REPORT UPDATE

Application No: FG/115/17/PL

LOCATION: 44 Ferringham Lane
Ferring
BN12 5LU

PROPOSAL: 4 No. bungalows

SCALE 1:200 @ A1
DATE 14.05.2017
DRAWN sed
DWG No. 628-02 rev. C

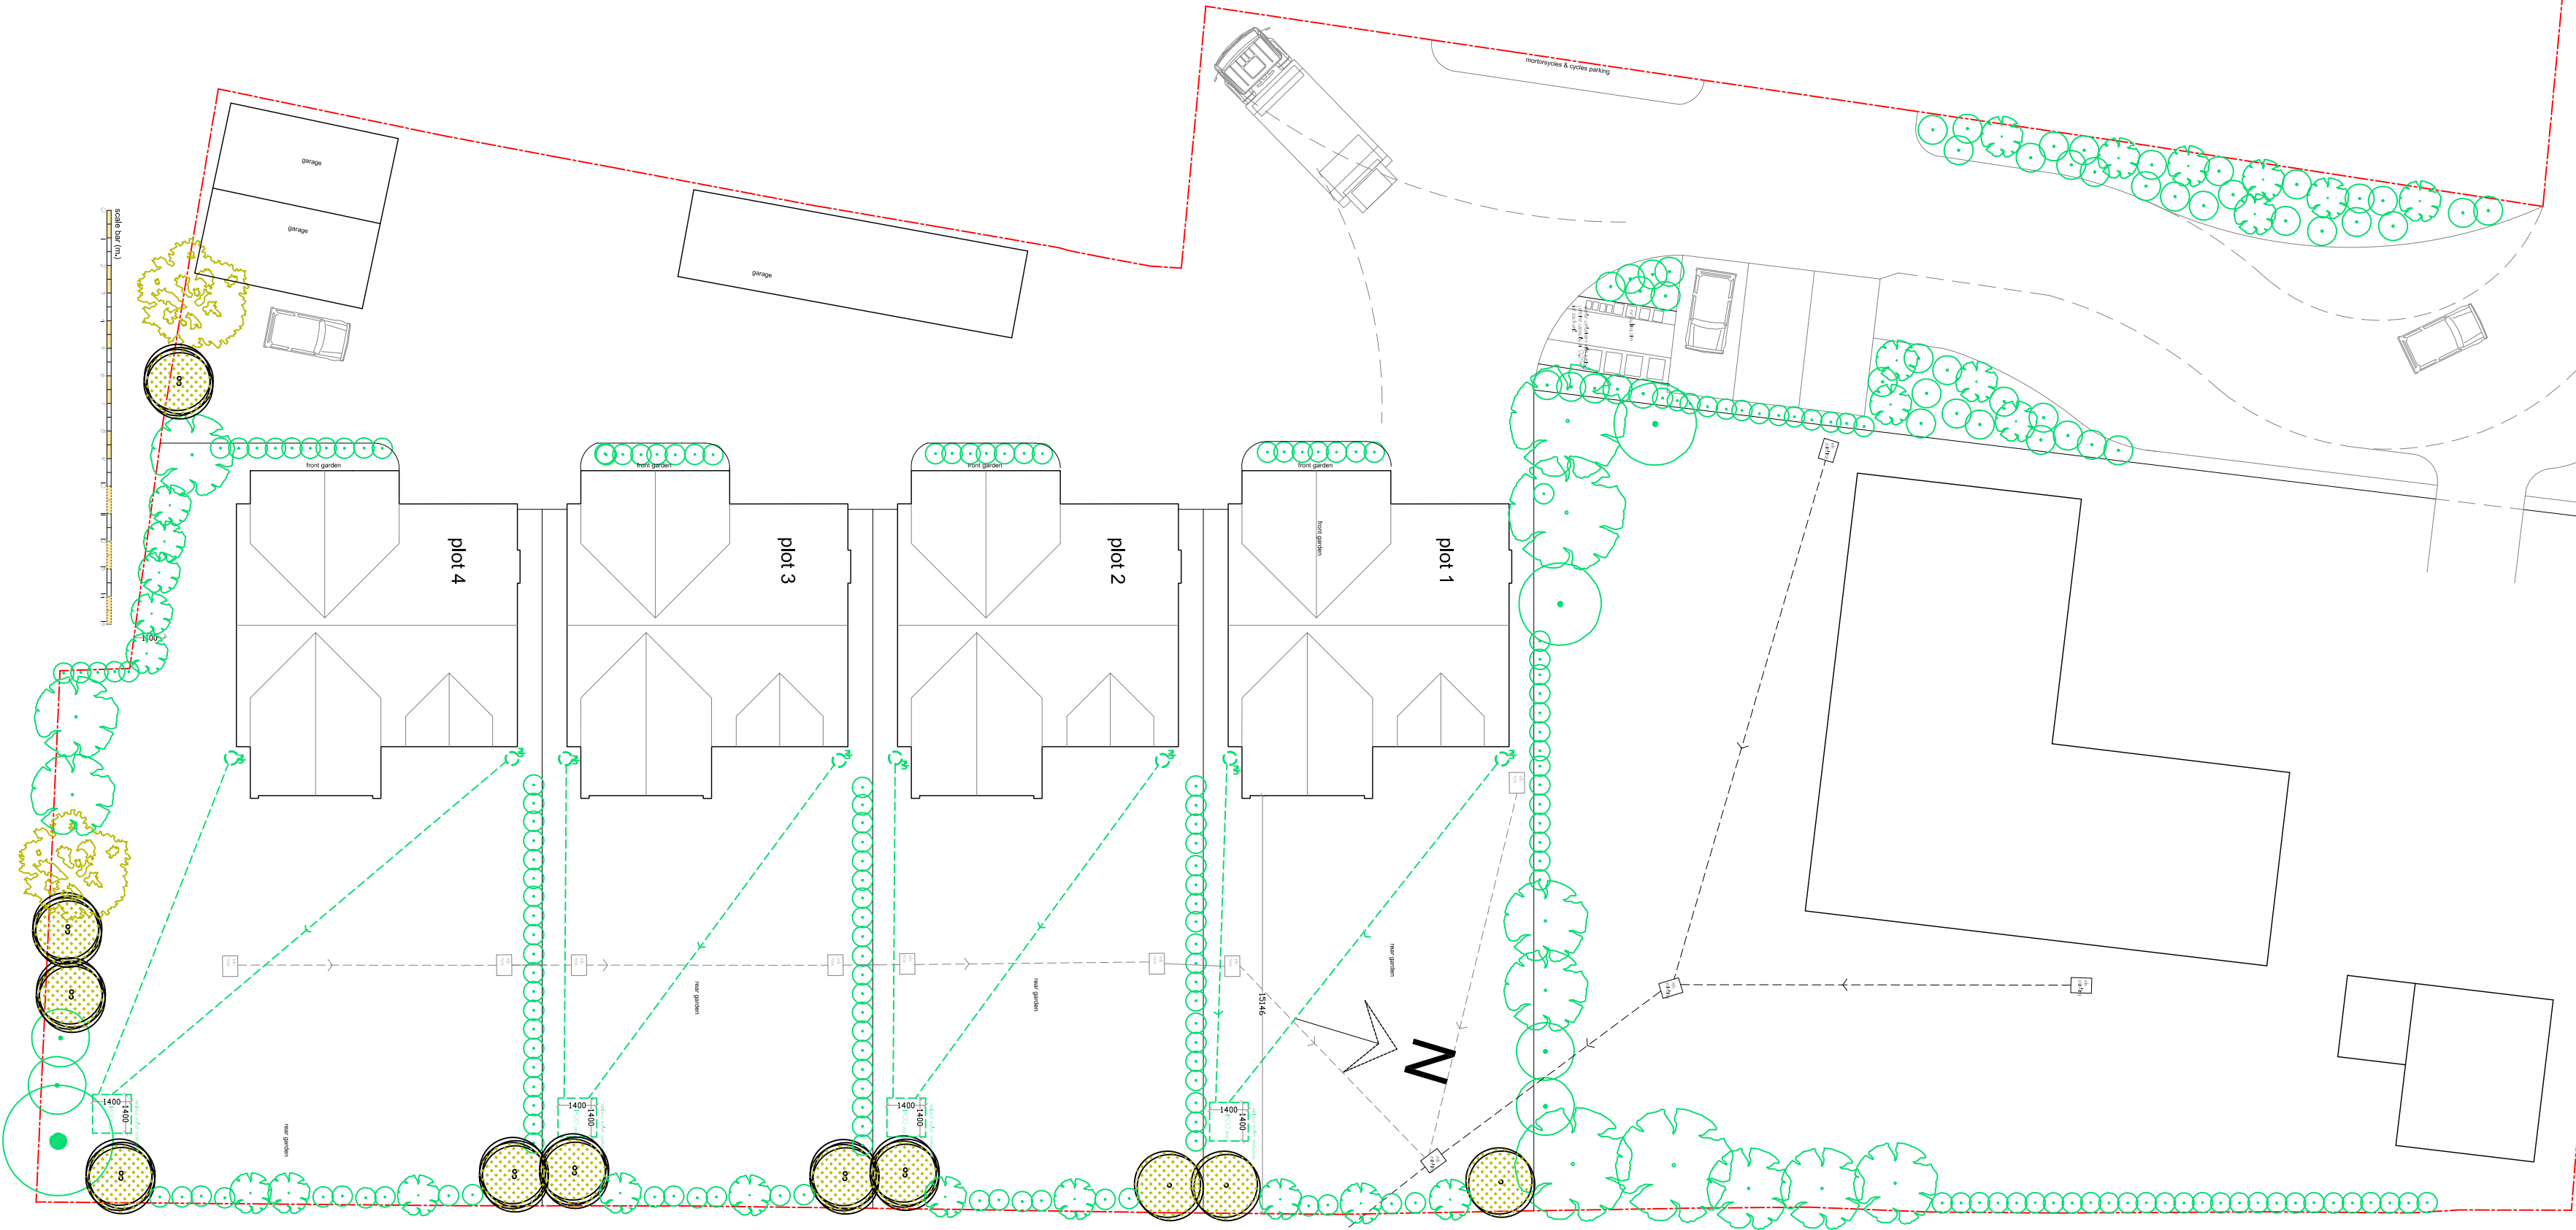
Second Response - Upon review of these plans the garages have been increased in size to 3 x 6 metres and the dwellings have been repositioned further west within the site.

The garages are now considered to be adequately sized. The repositioning of the dwelling has resulted in the area of hardstanding parking spaces allocated to each dwelling reduced. Hardstanding parking will now take place in the form of 1 space per dwellings provided in parallel fronting the dwellings.

The repositioning of the dwellings may impact the ability for larger vehicles (Fire and Refuse) to turn on site. Swept path tracking plans should be provided to demonstrate that the ability for larger vehicles to turn on site has been retained. This turning area should not use any area allocated for resident parking.

DWG No. 628-03 rev. C

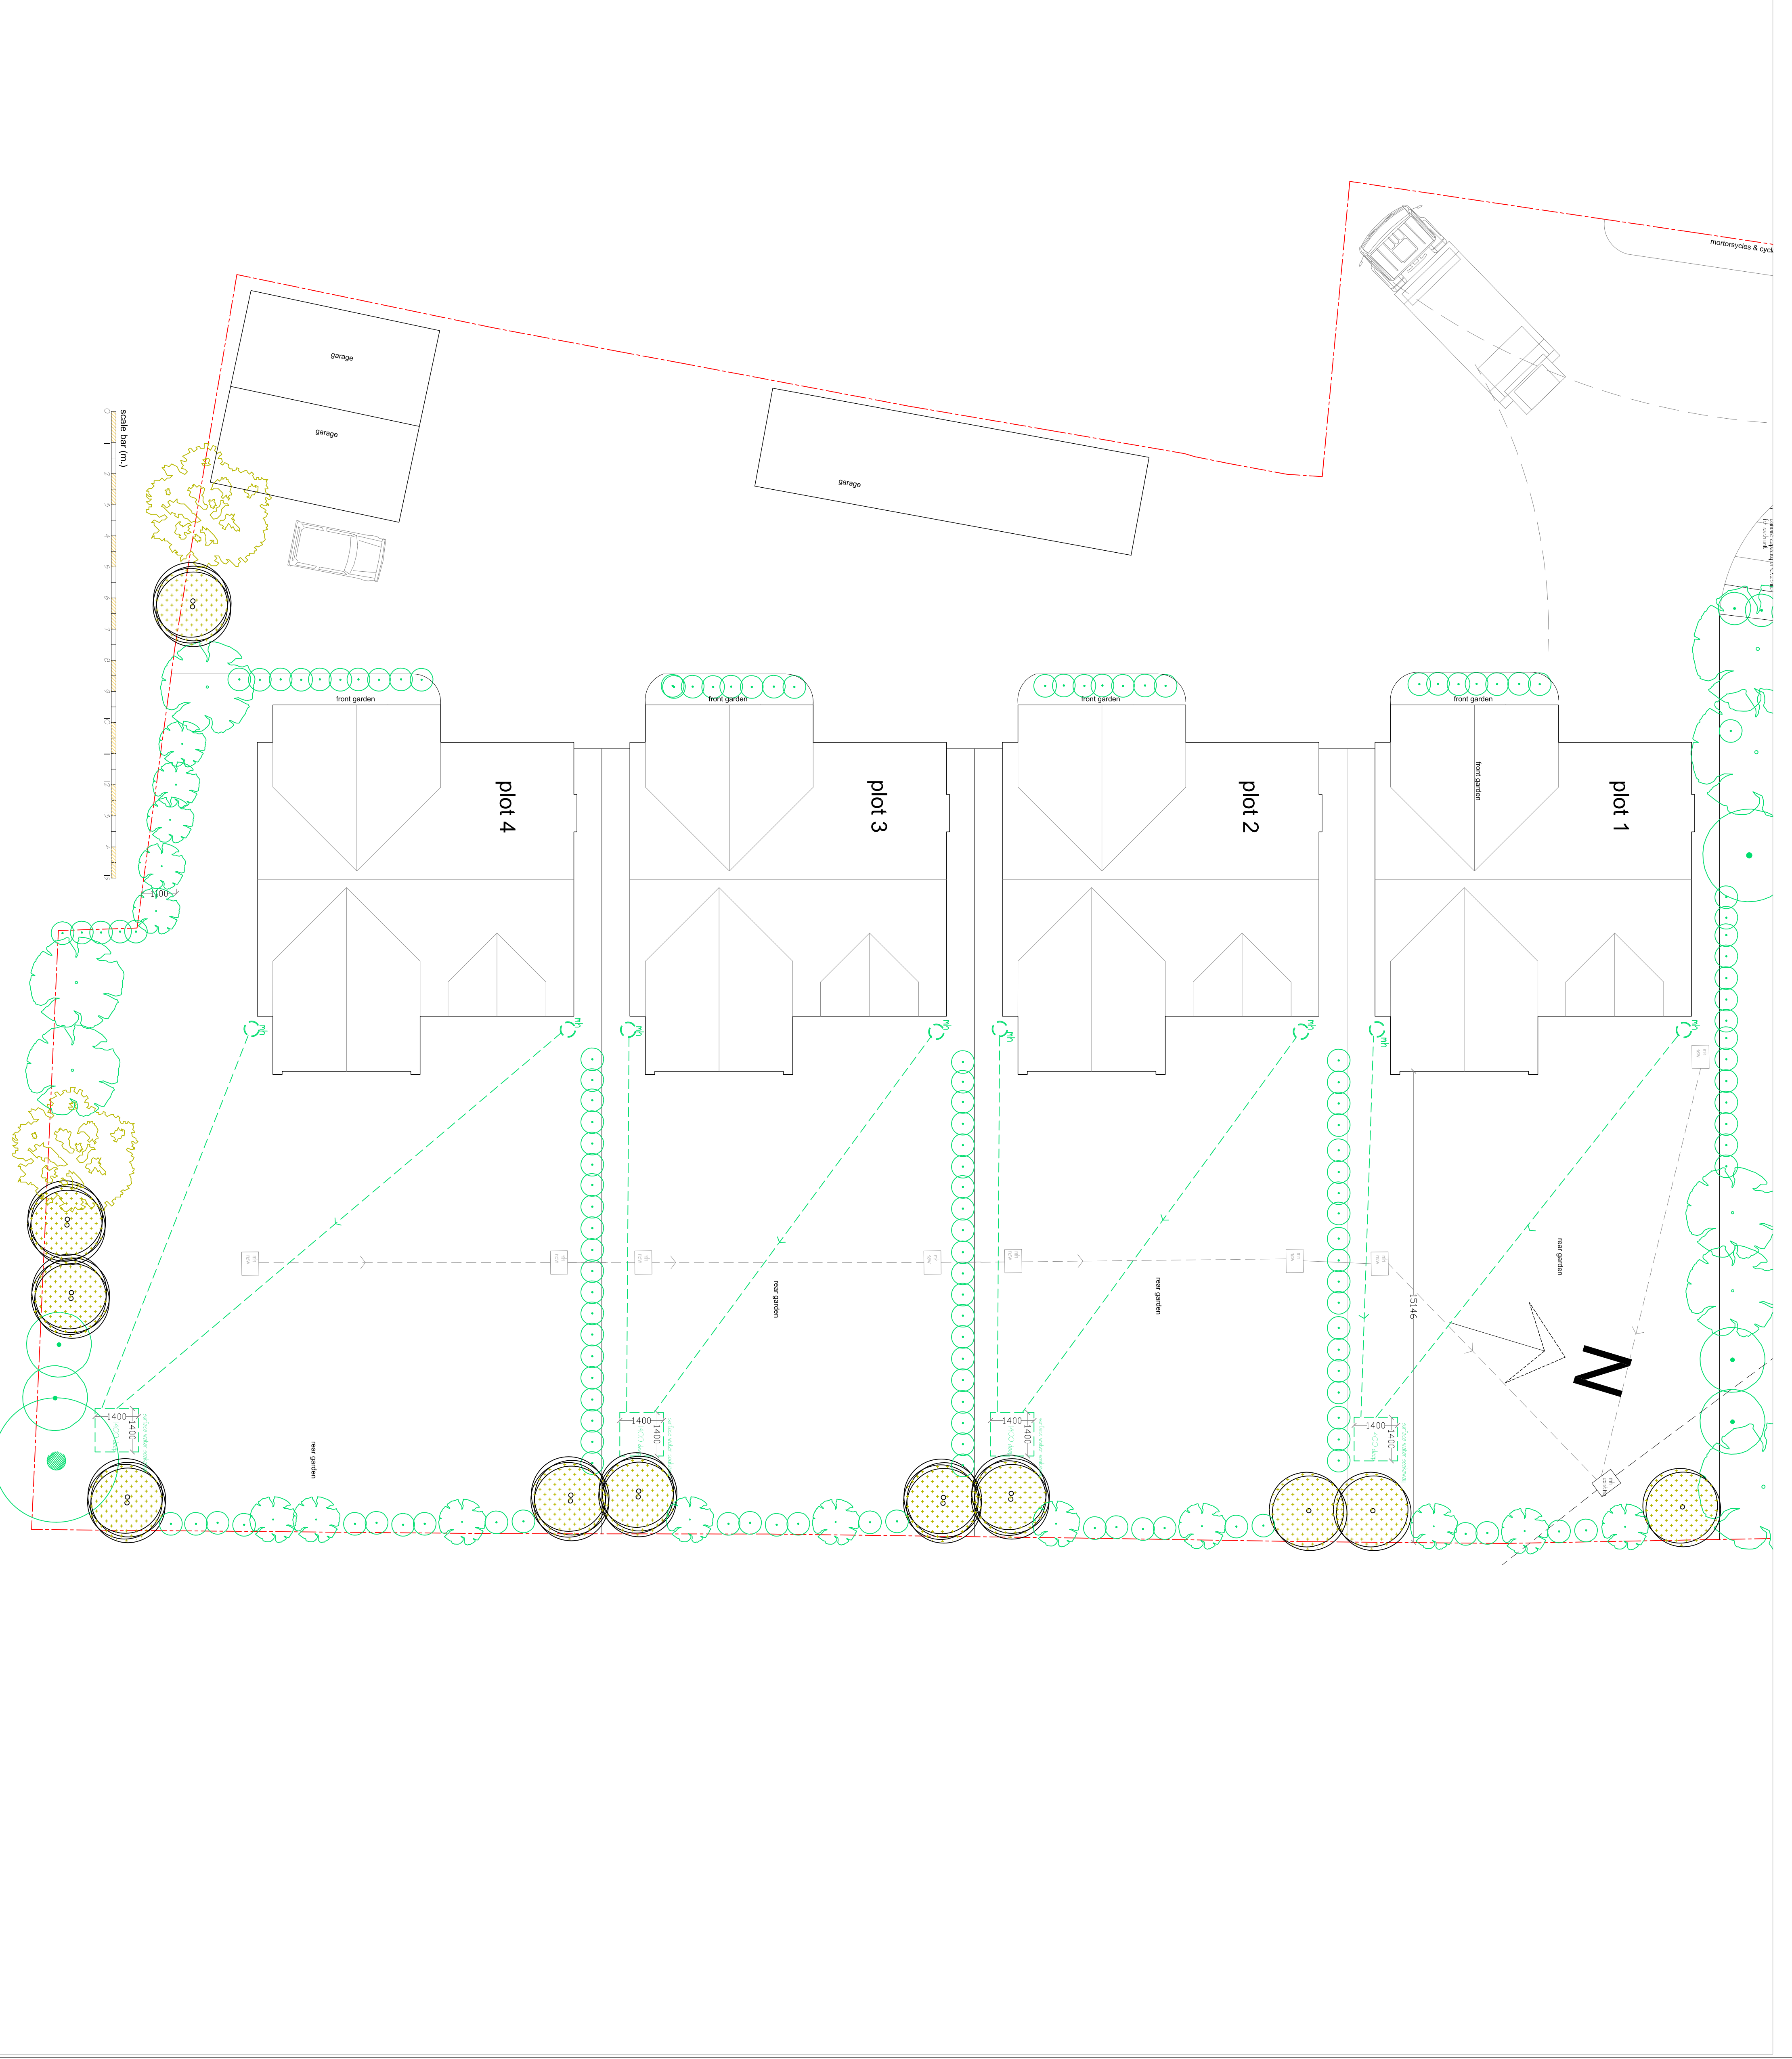
Third Response - Swept path tracking plans 628-02 Rev D & 628-03 Rev D would be considered acceptable. Amendments to visitor car parking spaces on plan 628-02 Rev D are acceptable. The tracking intersects with the parking area fronting plot 1, but the tracking does not require the whole of the hardstanding area and as such turning for larger refuse / emergency vehicle is acceptable.
